Your ref: 3/2018/0510

Date: 2nd June 2018

Planning Application 3/2018/0510: Construction of one block of six flats and associated parking. Land adj Black Horse Inn, Pimlico Road, Clitheroe.

Proposed Site Plan

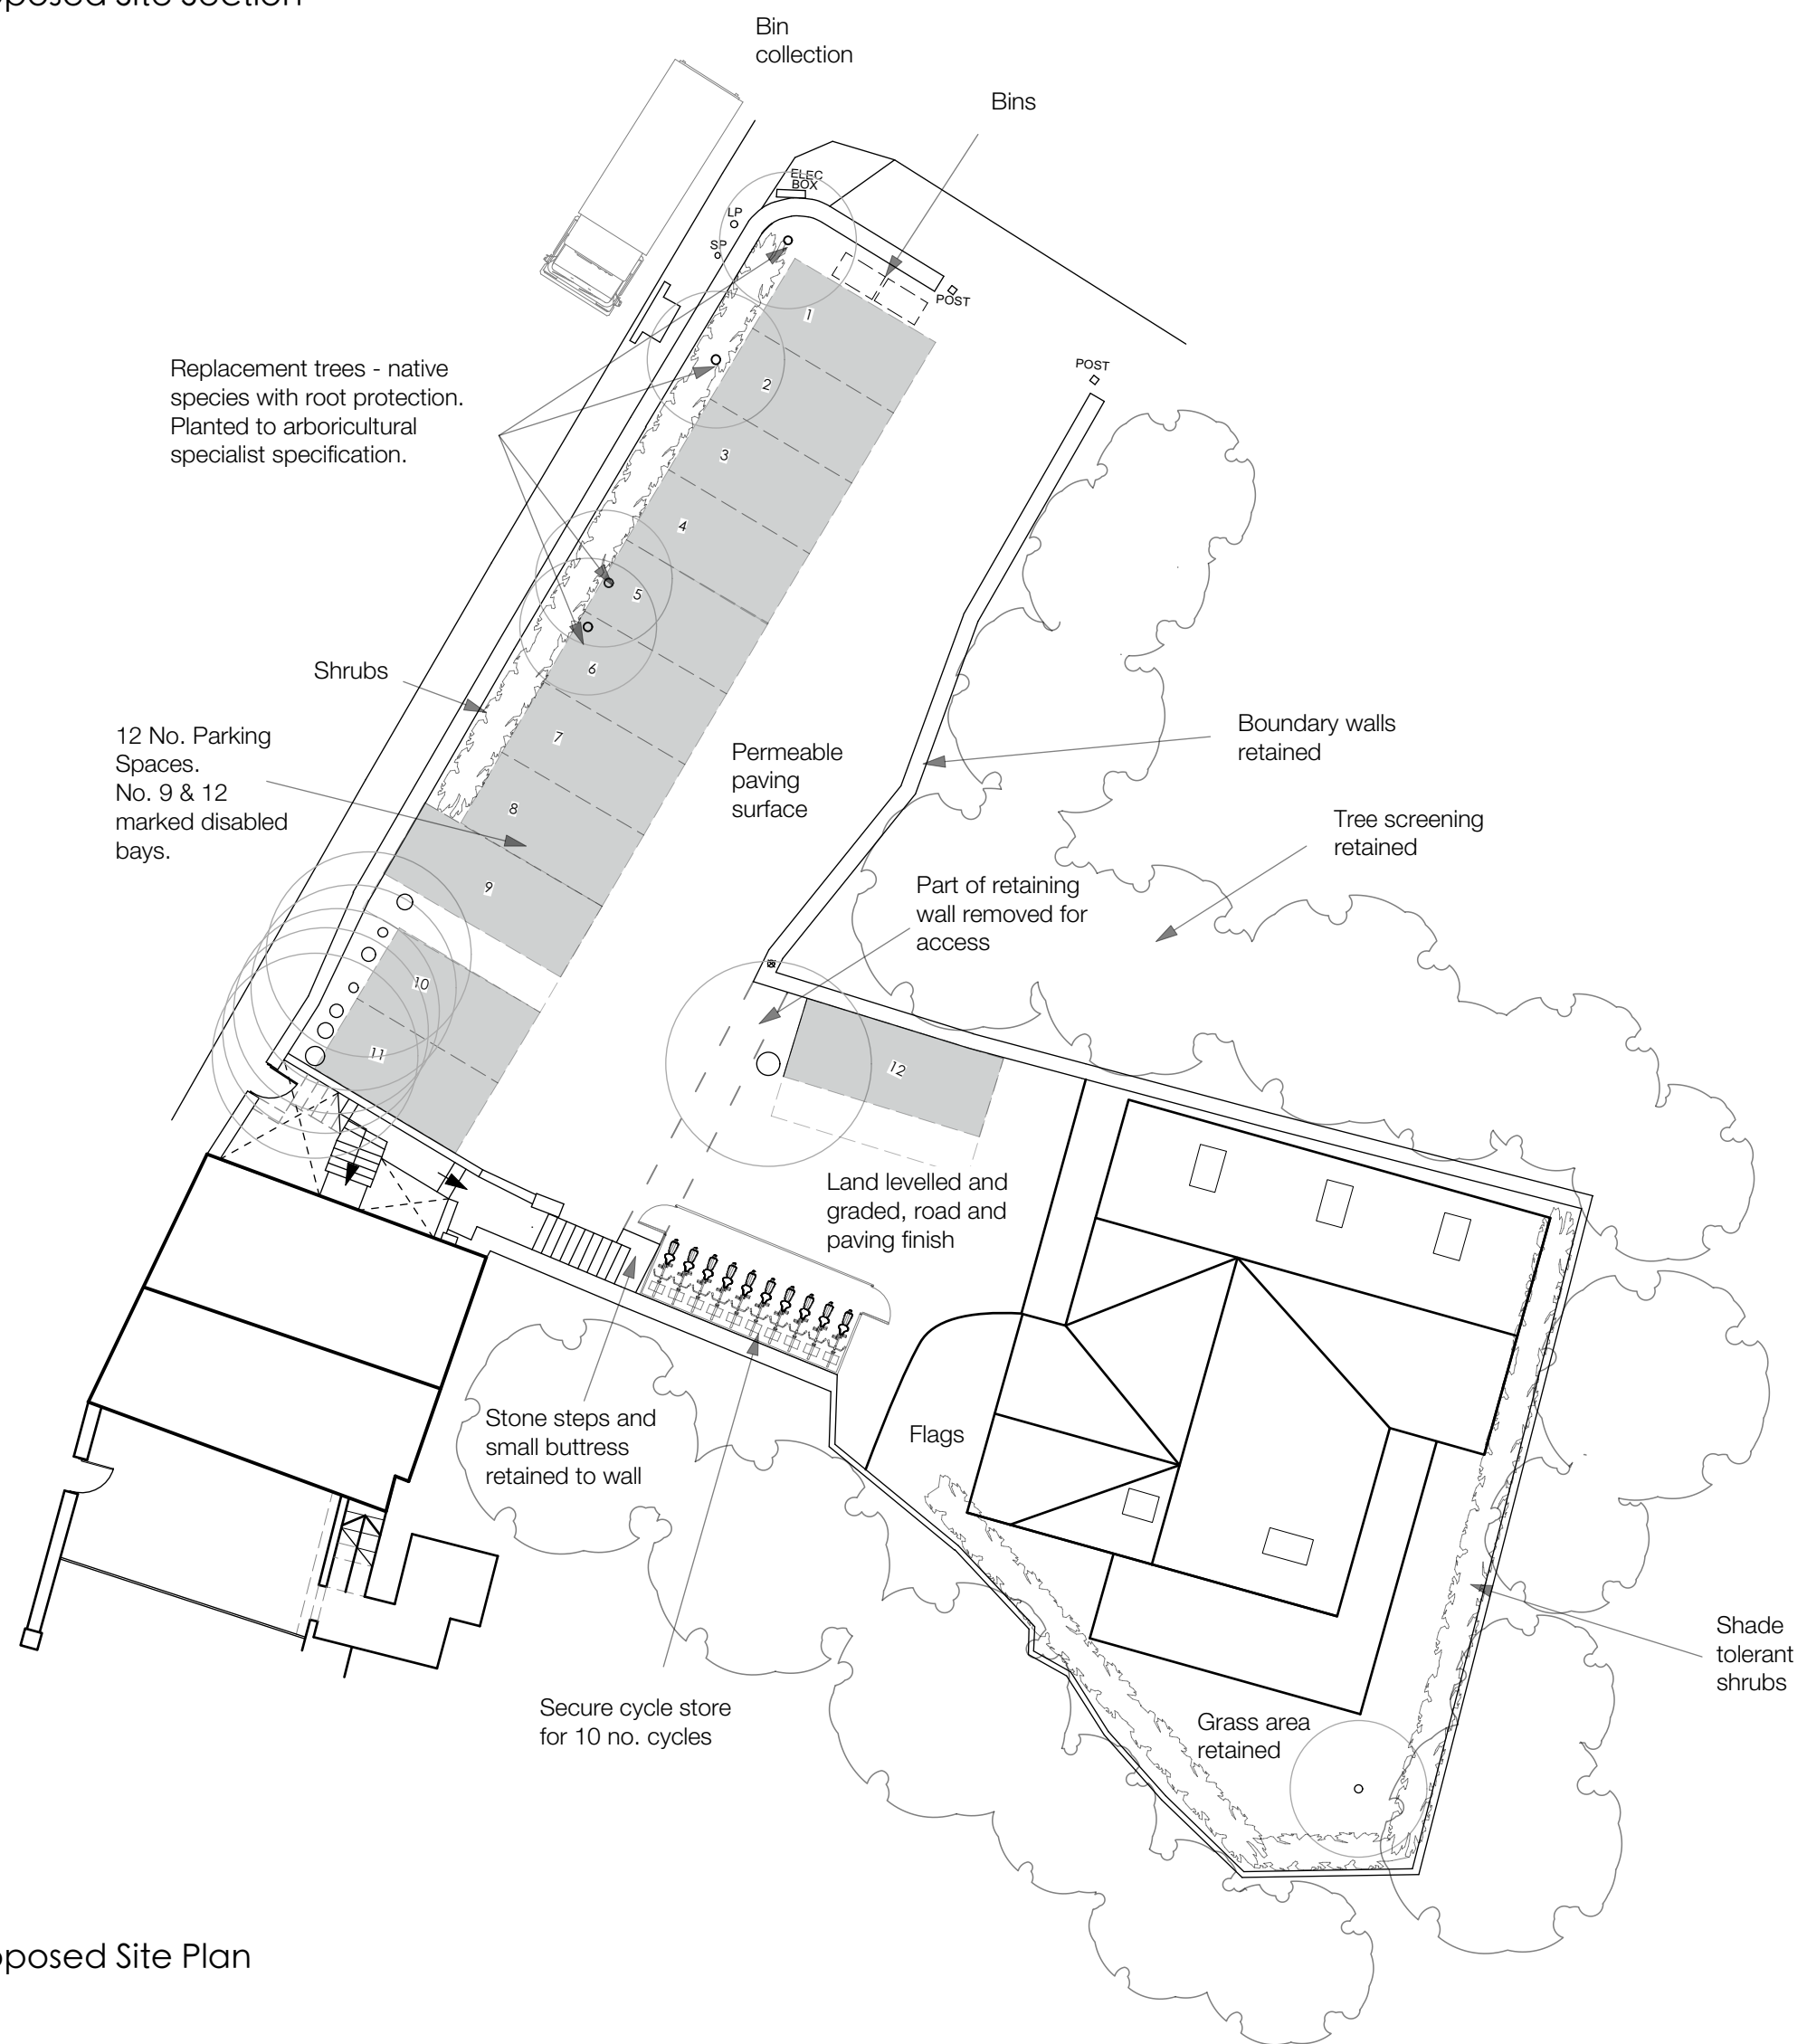
A lime kiln is shown alongside Pimlico Road within the proposed new parking area on the OS 1847 1:10,560 mapping (sheet Lancashire 47), with a second possibly under the site of the present 'Coach House'. These were served by a limestone quarry to the east, outside the development area. The kilns had been lost before the publication of the OS 1886 1:2,500 sheet (Lancashire 47.10), and areas of what appear to be spoil tipping and a rectangular building now occupy the proposed development site. A circle, possibly (even probably) a new lime kiln is also shown to the rear of the future site of the 'Coach House'. To the south of this 'Rockmount' appears to have been constructed, but the 'Coach House' has not yet been built.

The 1912 edition of the 1:2,500 mapping is the first to show the Coplow Hill Lime Works to the east of the development site and its railway link across Pimlico Road. The railway runs through the plot immediately north of the proposed building and through the centre of the proposed parking area. The boundary and revetment walls around the site all appear to have been constructed by this time, as does the 'Coach House' but not its rear extension.

It seems probable that the revetment wall identified as 'E' in the Structural Survey (SS) represents the southern side of the former mineral railway and that the exposed masonry to revetment wall 'F' see on the right side of SS photograph 5 represents the start of the bridge structure. Both of these walls appear to be retained by the proposed development. Whilst it is possible that buried remains of the lime kilns or post-1847 buildings exist on the proposed development site, these are not considered to be sufficiently important as to require any archaeological response. A section of a pre-1912 retaining wall (wall 'A' in the SS) is required to be removed as part of the development and land to its south excavated. This wall is likely to be contemporary with wall 'F', which contains the former bridge abutment, and is presumably jointed into wall 'E'. Wall 'A' is considered only to be of local significance, and given that the bridge abutment and northern section are to be retained, we would not object to its removal and would not consider any archaeological recording to be required.

We are somewhat concerned that the proposals to remove all of wall 'A' do not match the assumptions made in the Structural Survey:

"... As part of the development of the site it is proposed to remove the upper section of the retaining wall to allow access, the removal of the upper section of wall should not adversely affect the stability of the retaining wall" (SS page 3) and the council should be satisfied that its complete removal will not adversely impact the stability of former bridge abutment and the southern wall to the former railway line (walls 'E' and 'F'), or that appropriate mitigation proposals are in place before granting consent.
